Please upload onto Ocella the email below which is the additional consultation response from **ADC Drainage Engineers** to **BN/30/20/DOC** – Angels Nursery, Yapton Road, Barnham.

To summarise, we do not recommend discharge of the drainage conditions at this time.

Key
ADC Original comments
ADC further comments 16/06/20
CG response 25/06/20
ADC further comments 30/06/20
Note strike through indicates closed comment.

PRECAST CONCRETE CONTROL CHAMBER

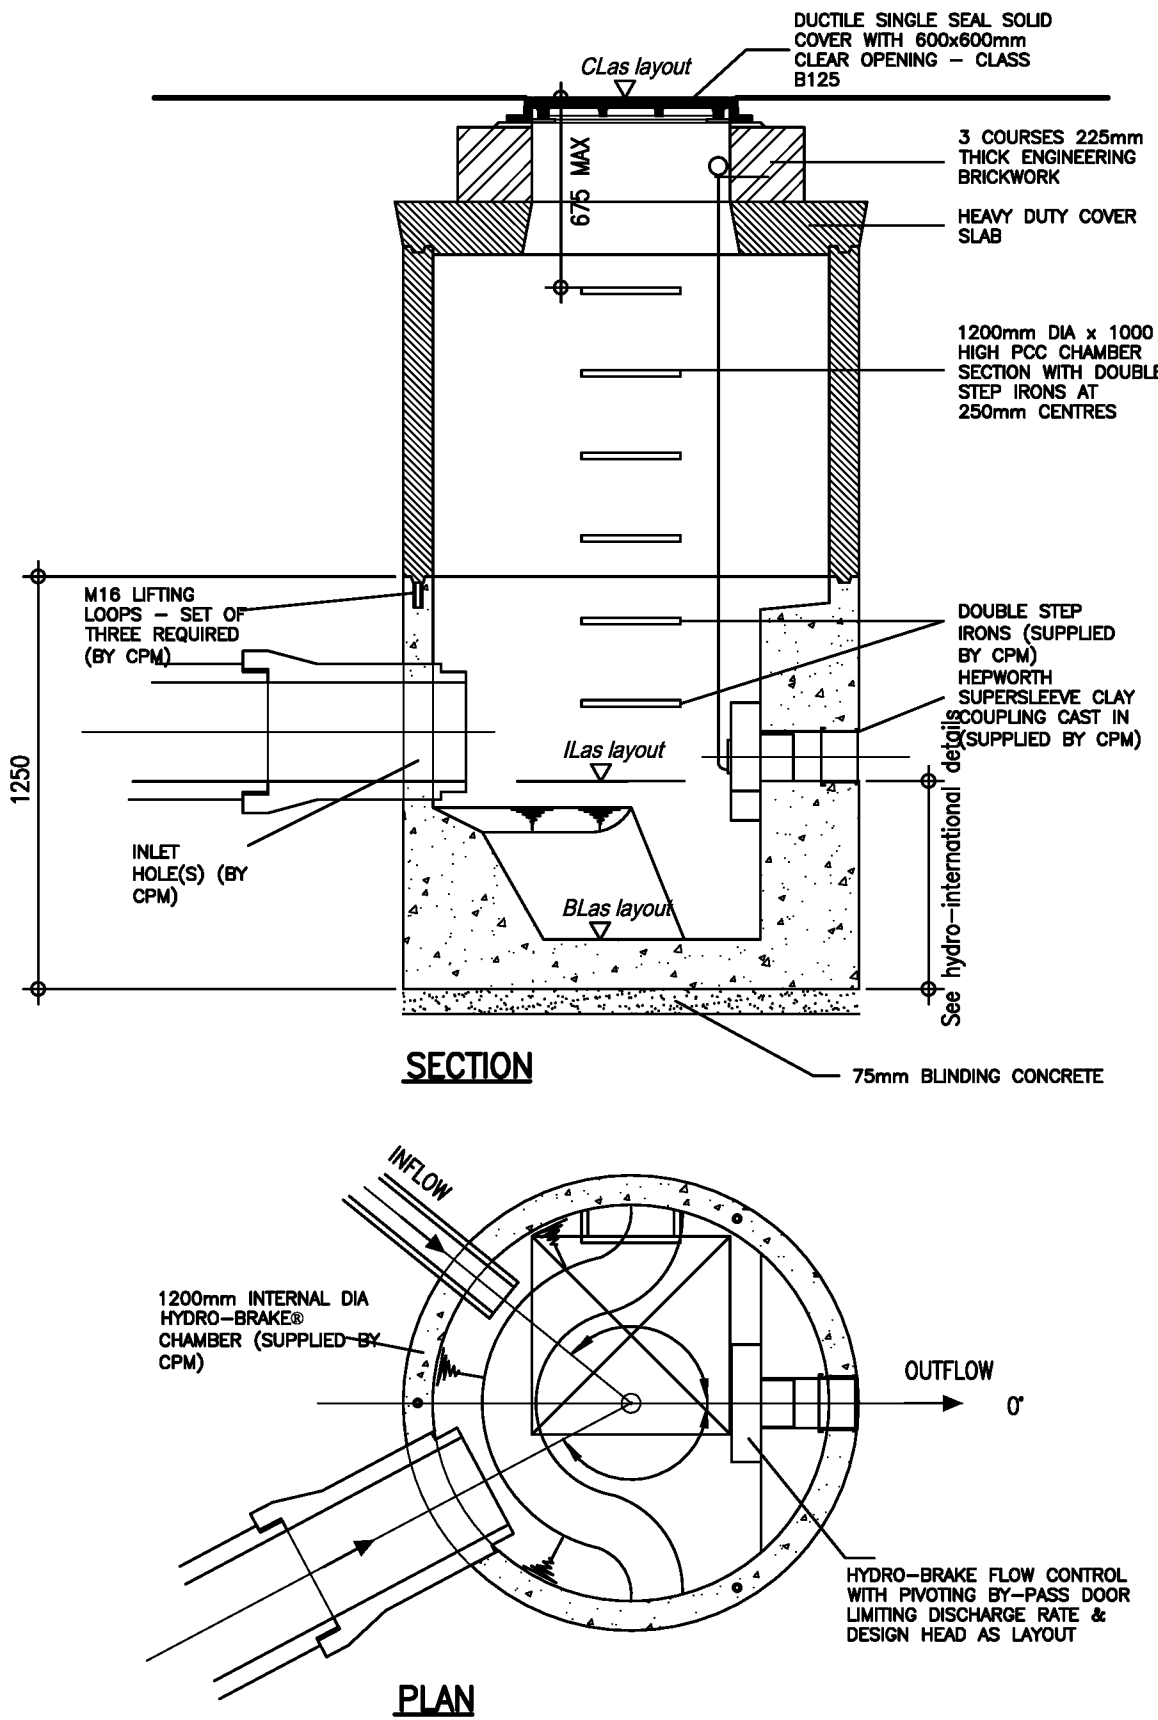
64. ~~Hydrobrake chamber detail — rings to be surrounded in 150mm thick concrete and to be extended down to the bottom of its base. All to be ST4 concrete. Add benching construction notes and include hydro international details referred to. Note is not clear that surround extends to bottom of base; benching note missing; hydro international details not included. See revised detail on drawing S402. Okay.~~

TYPICAL PRECAST CONCRETE
CATCHPIIT

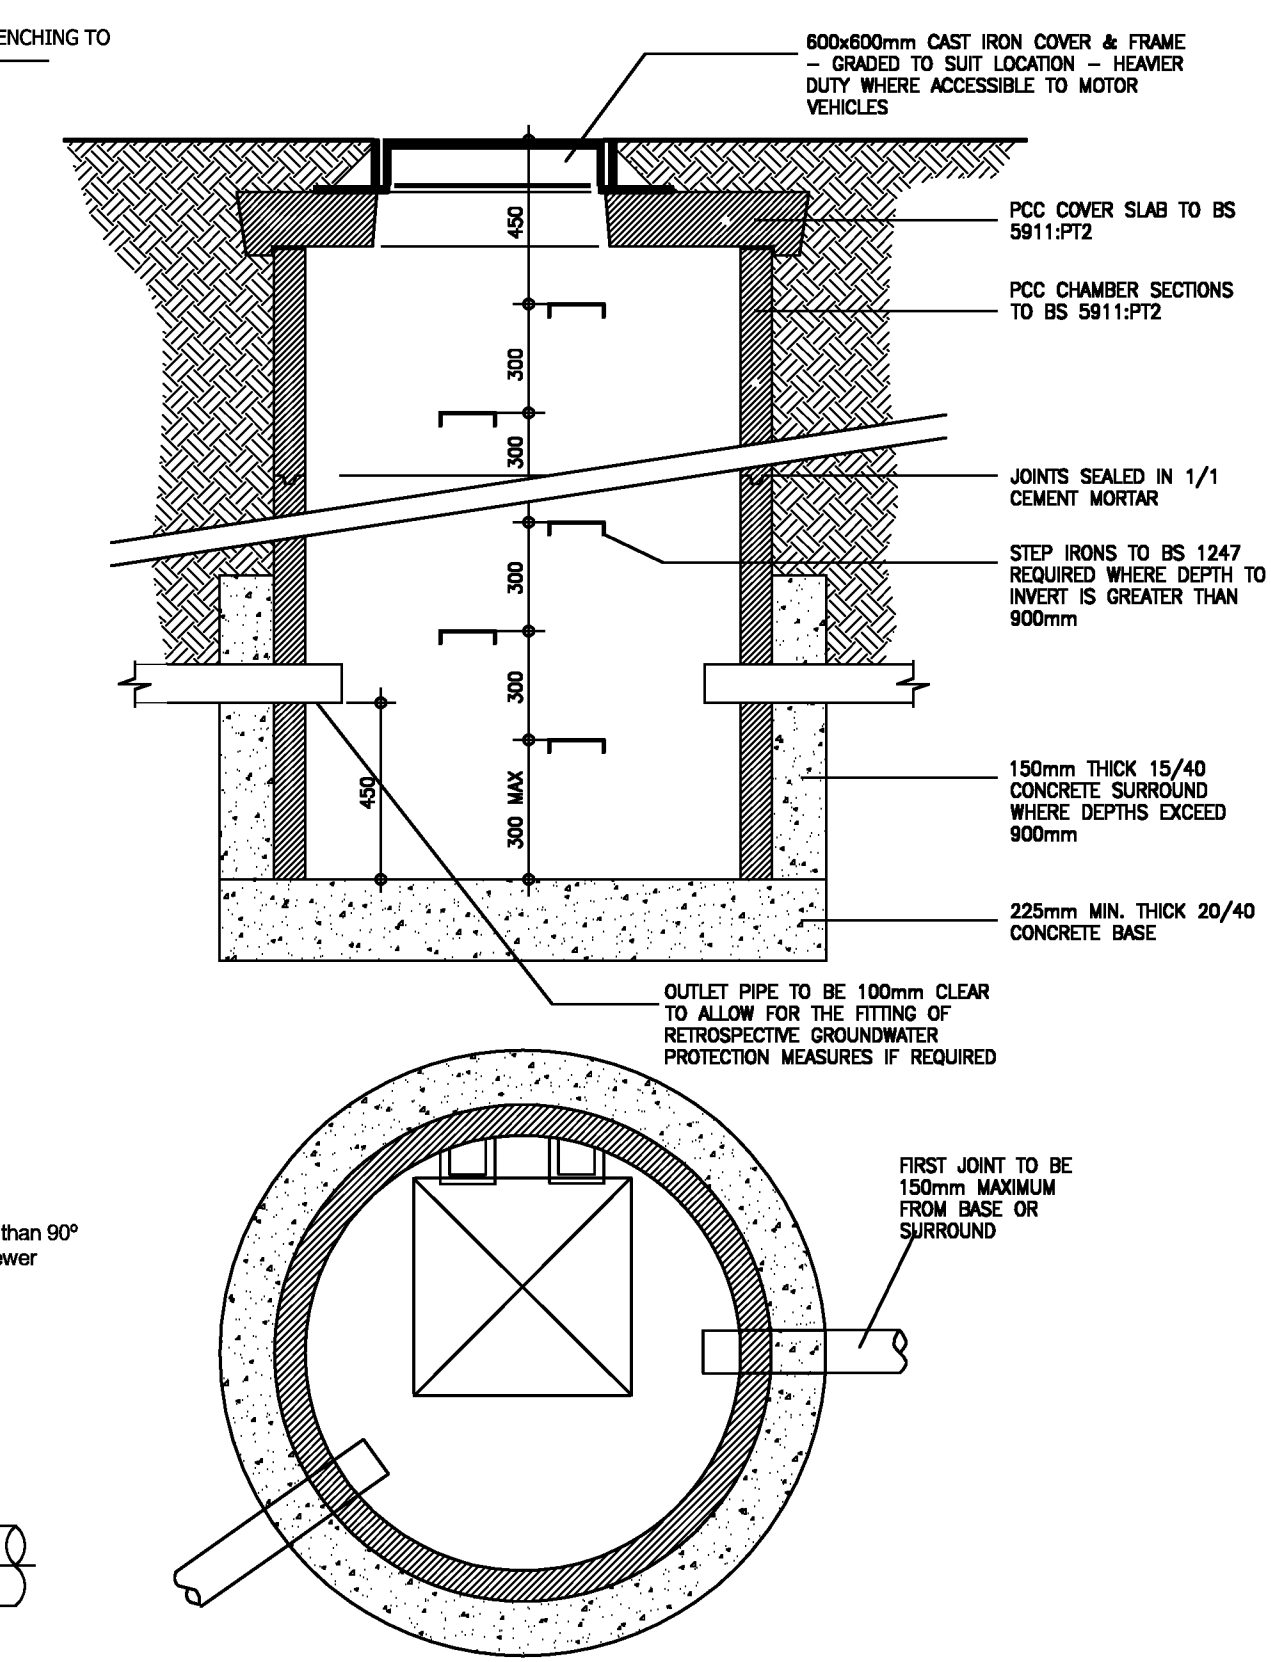
65. ~~PCC ring catchpit detail — unsure if this type is being specified anywhere? If, so detail where and include brickwork under manhole cover/frame and extend concrete surround up to top of cover slab. Specify ring diameter. Unclear as to where specified; include MII schedule. The Highway chambers at the northern end of the access road are catchpits. MII schedule has been added to the latest layout. Okay.~~

ADOPTED OUTFALL HEADWALL
SCALE 1:25

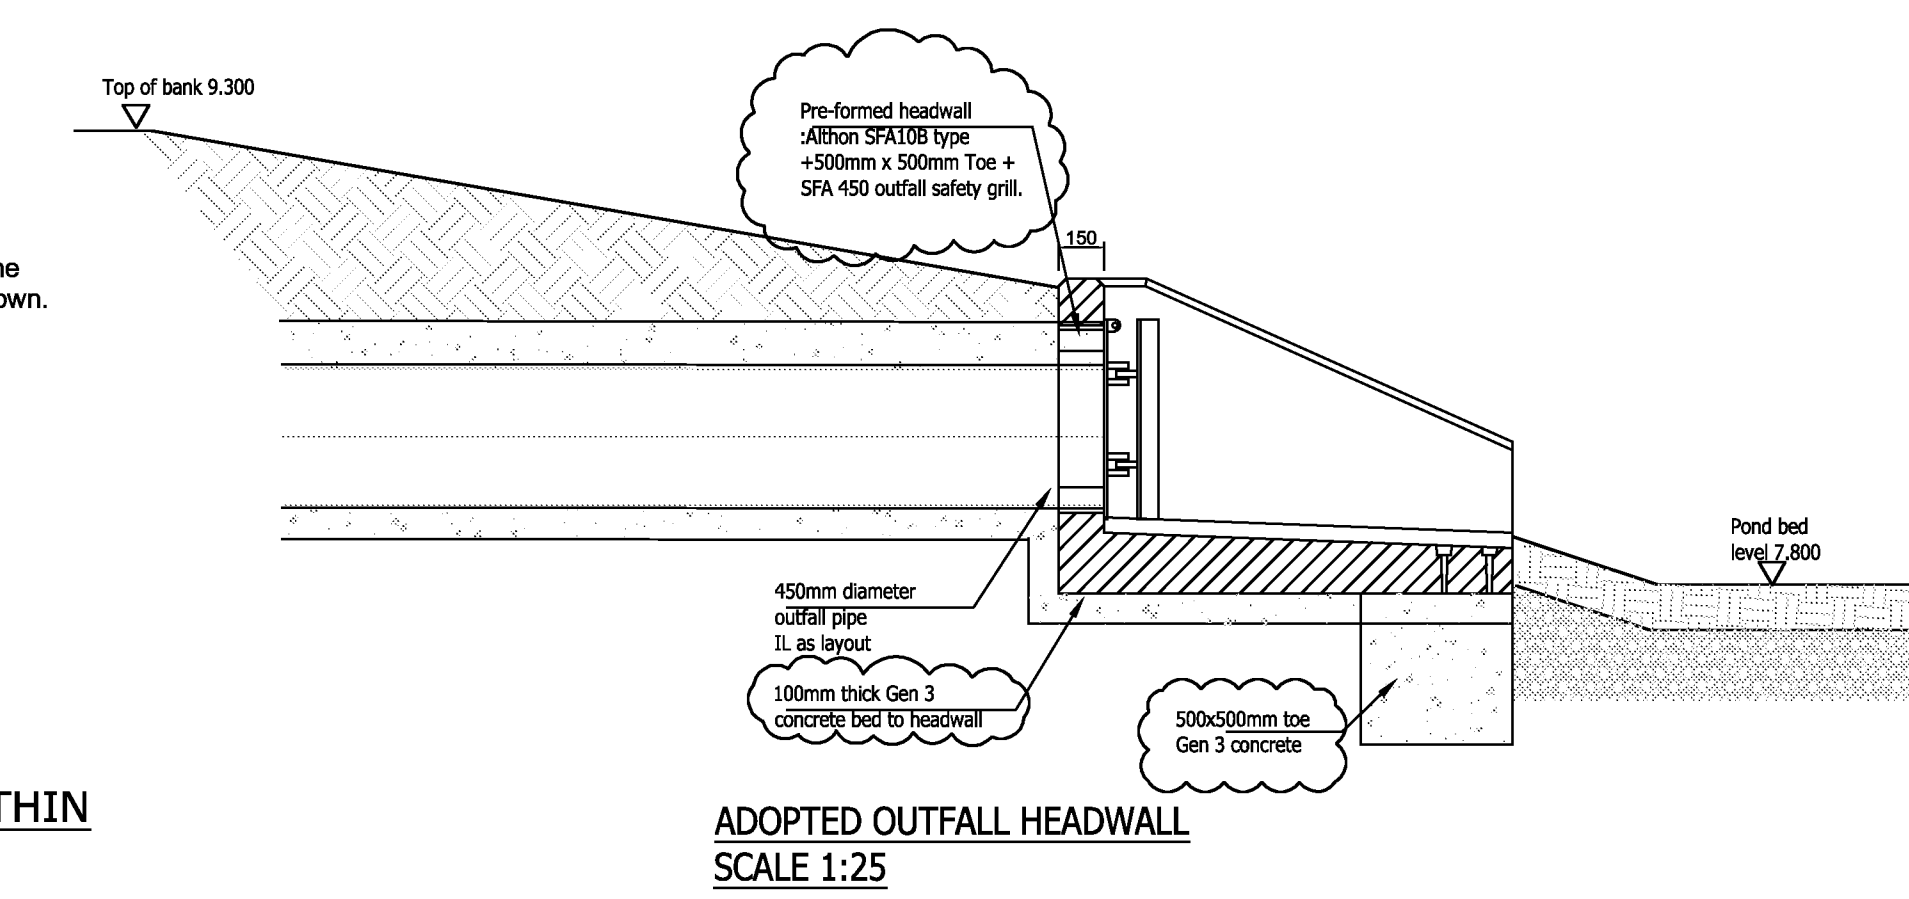
67. ~~Adoptable outfall headwall detail – remove flat grille and specify cranked including bar spacings, etc. Incorporate Athlon detailed drawing within this drawing. Pond bed level shown as 7.800 but 7.900 on plans. Please address points. Pond base level is shown as 8.000 on plan with a reduced wet base level of 7.750. The detail has been revised to show a sloped Athlon Trash screen. Okay.~~

DISTRIBUTION/COLLECTOR TANK DETAIL WITHIN TANKED PERMEABLE PAVING (MARKED DT ON LAYOUT)

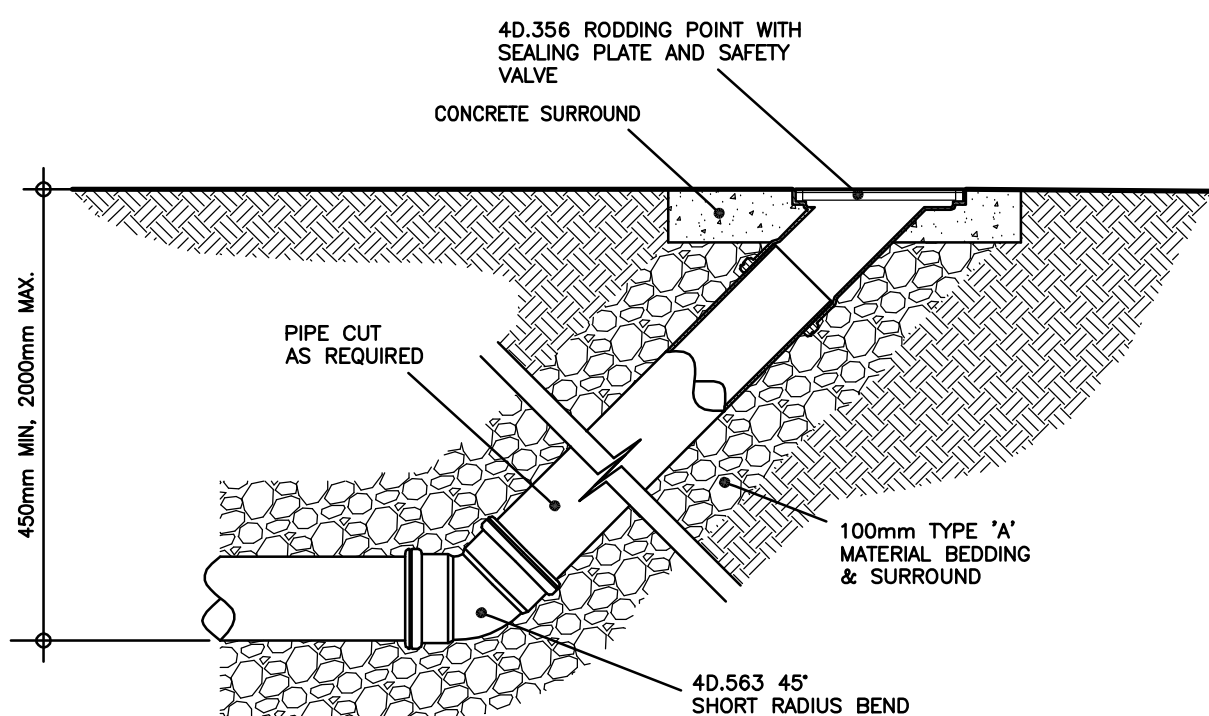
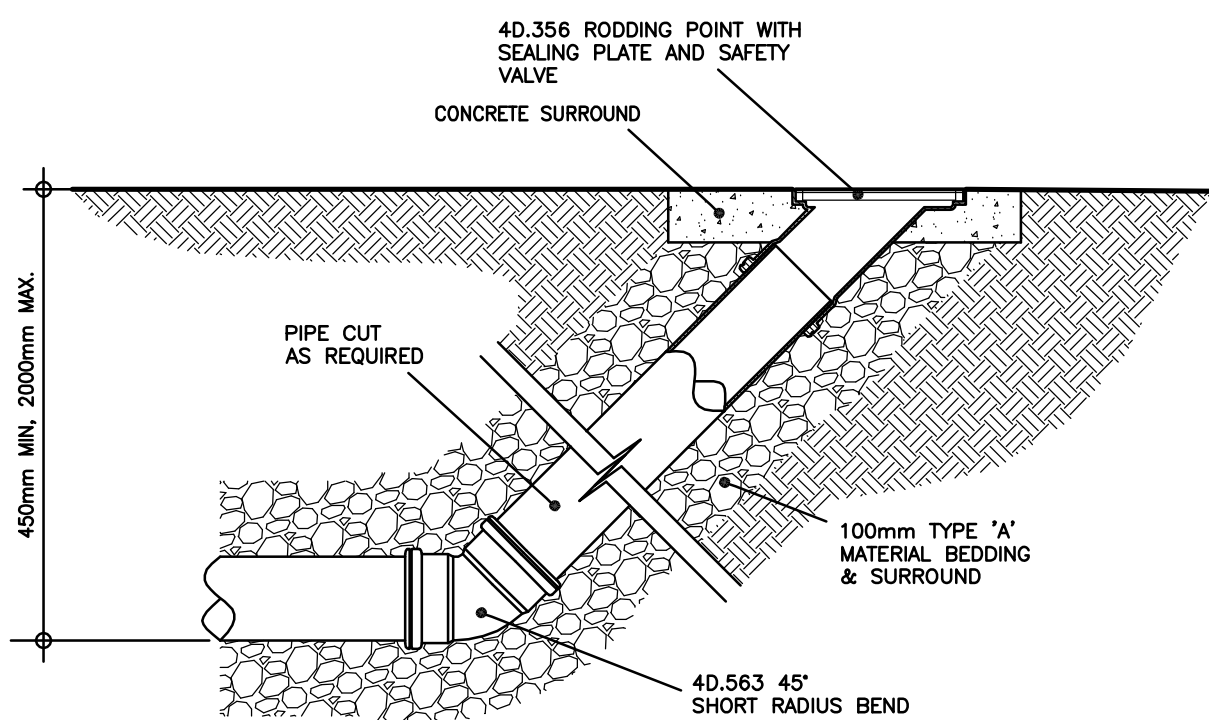
73. Provide construction detail distribution tanks on permeable paving outlets. *Please make it clear that invert level of outlet tanks is at formation level. Note added to DT detail on drg S101.*

CONCRETE BAFFLE DETAIL

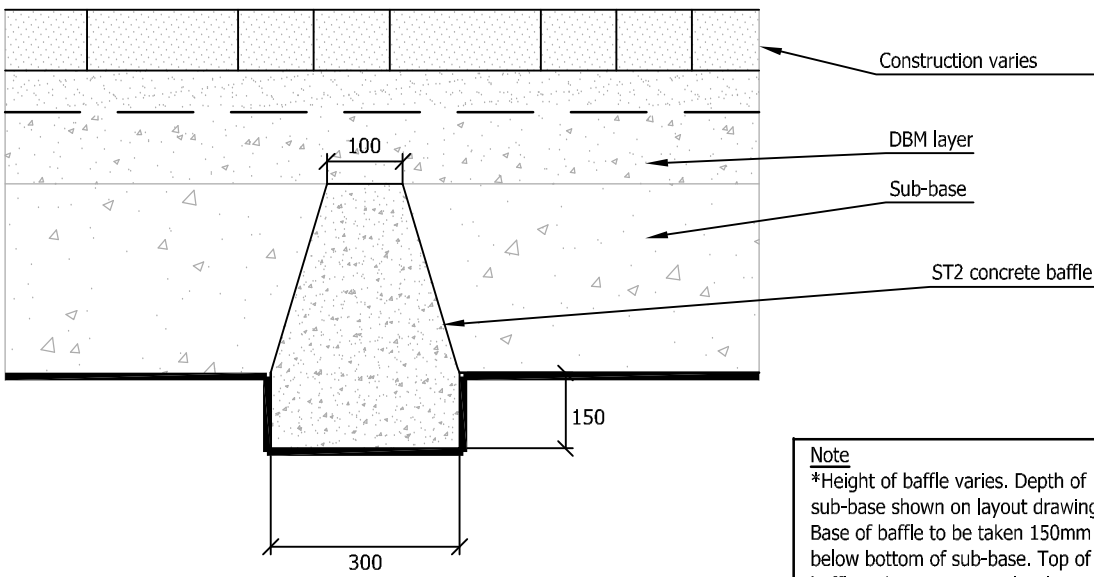
71. ~~Baffle detail – Make it clear that the top of the concrete is level with the top of the sub base. Okay.~~
72. Provide pond construction detail including impermeable liner and any necessary anti-buoyancy measures. Floatation calcs to be provided. *Please provide. Pond sections now shown on drawing S108. Flotation calculations not provided, please provide based on onsite GW monitoring. If further onsite winter monitoring was not completed please complete calculations and design based upon GW at surface. If a design cannot be achieved within the site layout based upon this, discharge of conditions and commencement on site will have to wait until at least next April, i.e. after adequate winter groundwater monitoring has been completed.*
